## Online Comment

**Application** H08-0260-25  
**Location** 61 HIGH STREET GOSBERTON SPALDING PE11 4NJ  
**Proposal** Removal of existing single storey extensions, replaced with new single storey extensions, garage conversion, internal alterations and covered porch

Dwg Title: **PROPOSED ELEVATIONS**

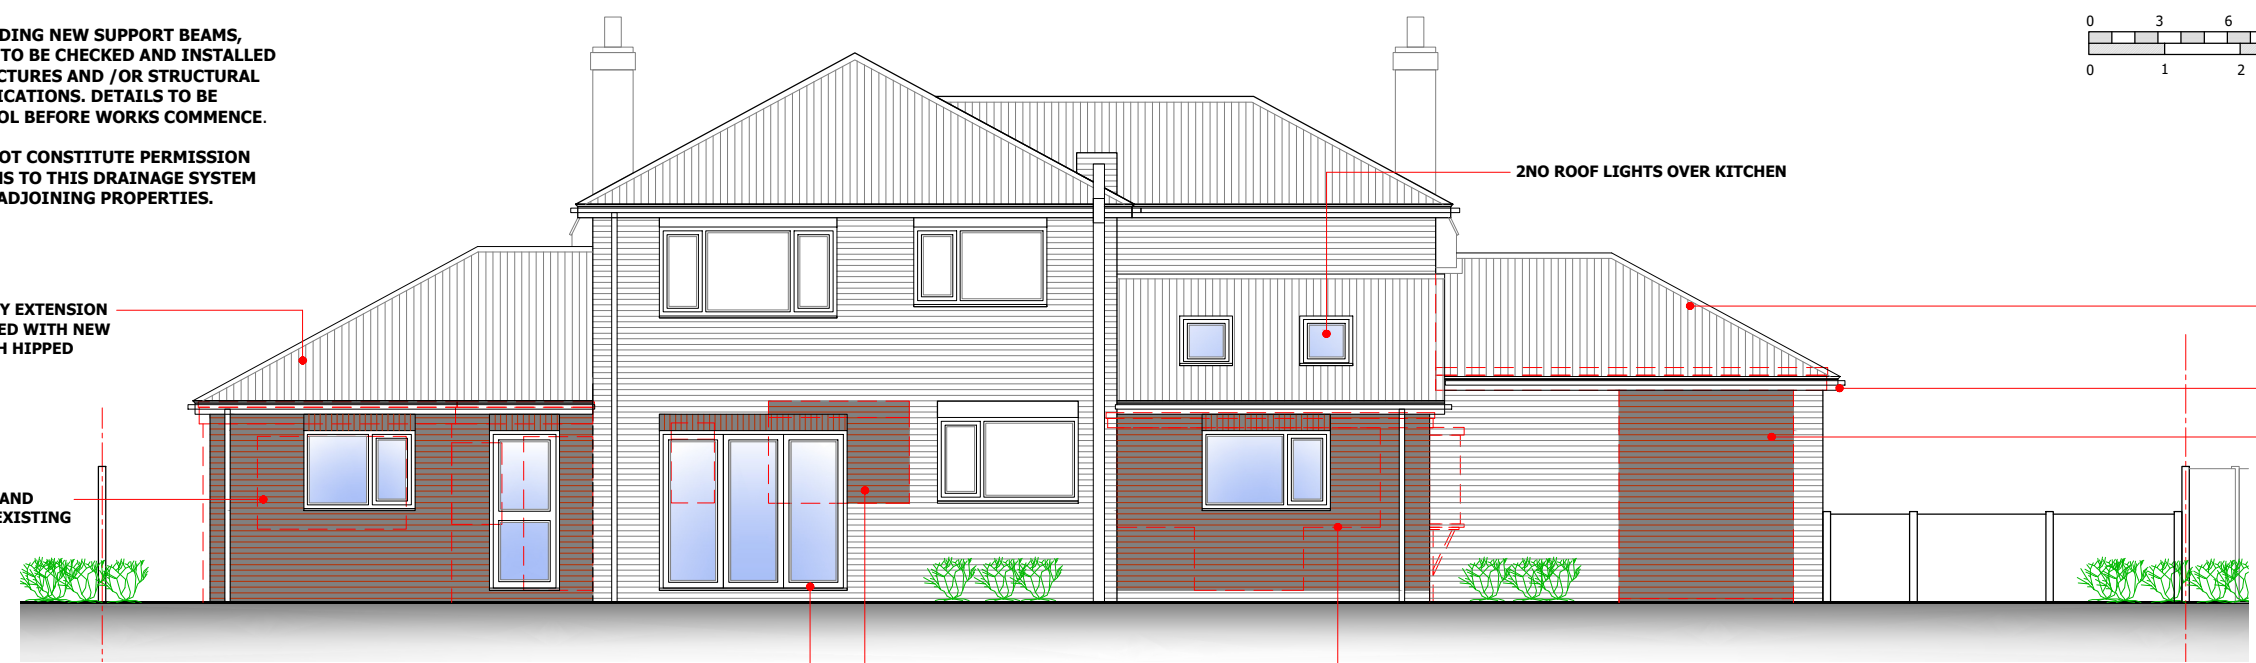
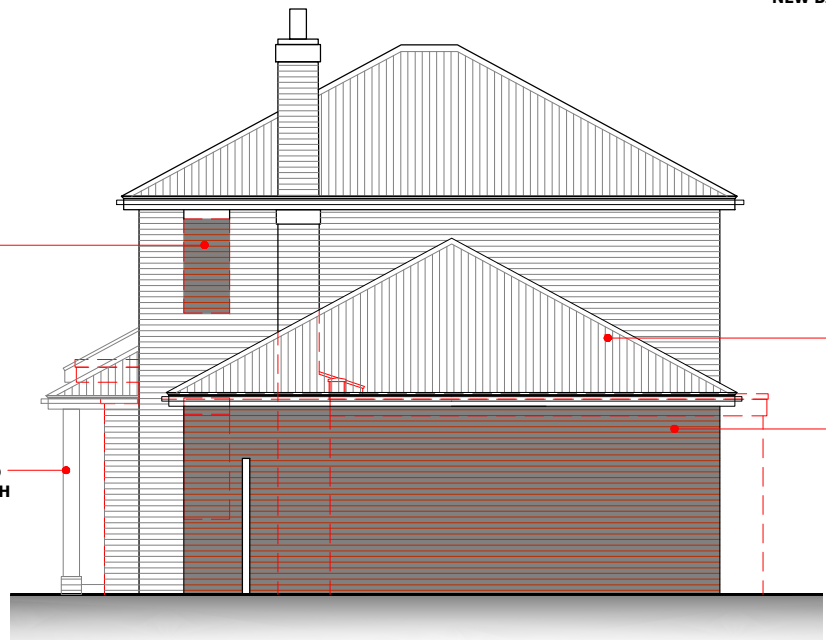
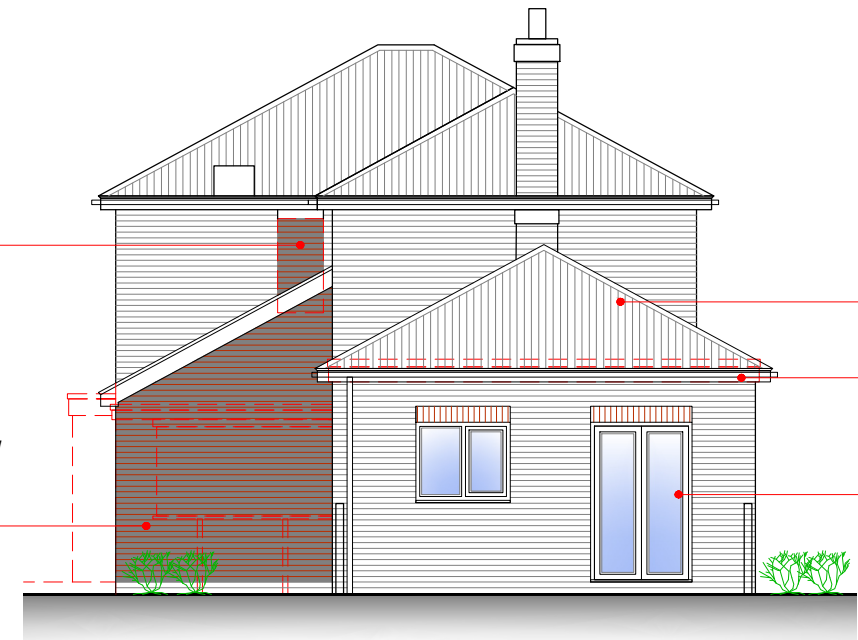
The proposed extensions are a marked improvement over the extant flat roofed structures. The proposal does include the use of UPVC fenestration etc, which would typically be unacceptable in a conservation area setting. However, as the site already features UPVC throughout the host property, it would be unreasonable to expect the applicant to be required to install traditional timber units in this specific instance.
